Re: SSD-76913969-Mod-1 – ALDI DISTRIBUTION CENTRE
475 Baggery Creek Road, Bredfield.

ARCHITECTURAL DRAWING PACKAGE - MODIFICATION STATEMENT

SBA Architects Pty Ltd is the Architect of Record for the above project. This statement is provided in support of Application SSD-76913969-Mod-1 to confirm the nature of the architectural drawing changes made to the approved SSD-76913969 set and to confirm that none of the changes give rise to any additional impacts on the approved development.

2 NORTH ELEVATION - WAREHOUSE 1 : 600

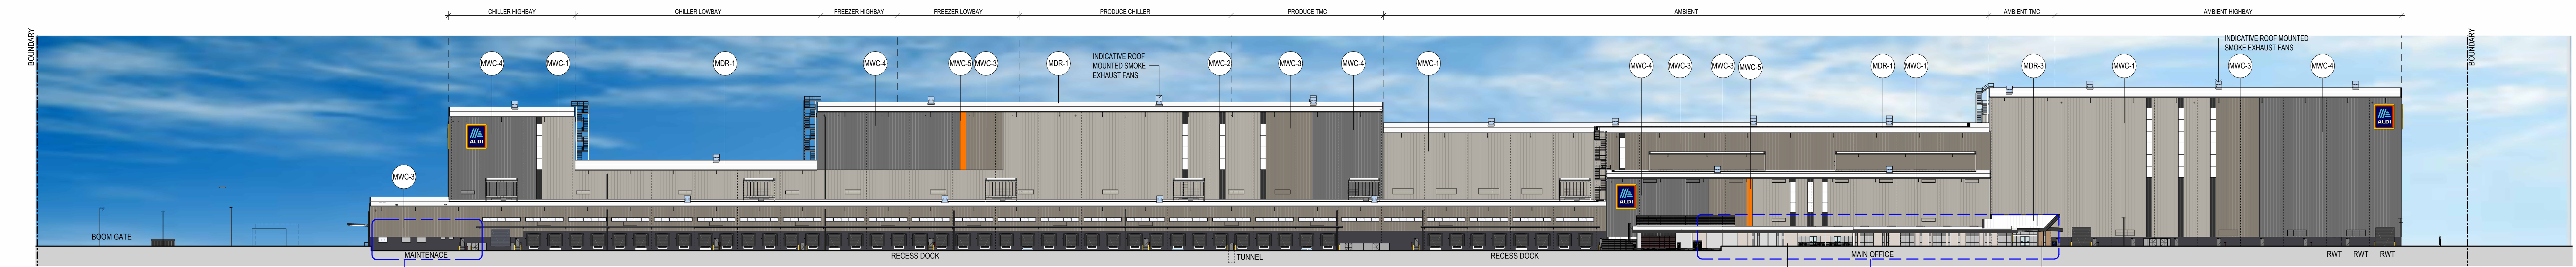
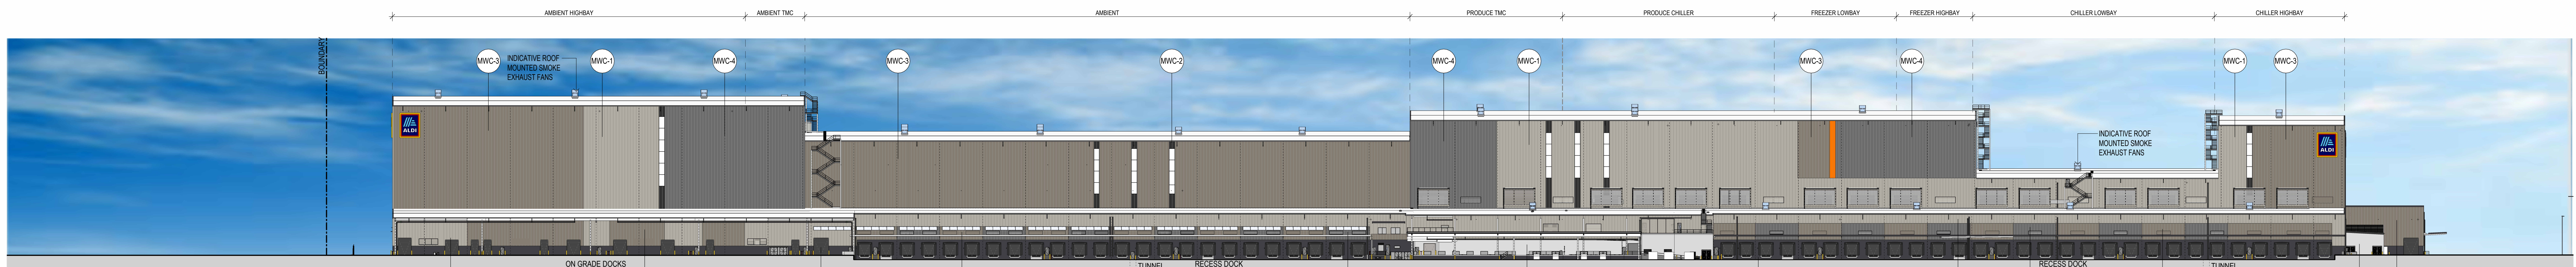
- Change 3 Additional Louvres (Drawing Ref: DA-140 Elevations Warehouse Rev: 1):**
 Louvres have been added as a result of design development for smoke make up air and ongoing engagement with FRNSW Fireious research building colour of the surrounding façade and have been incorporated into the updated Elevation drawings. The addition is minor, does not alter the approved external character of the building. No additional impacts arise.
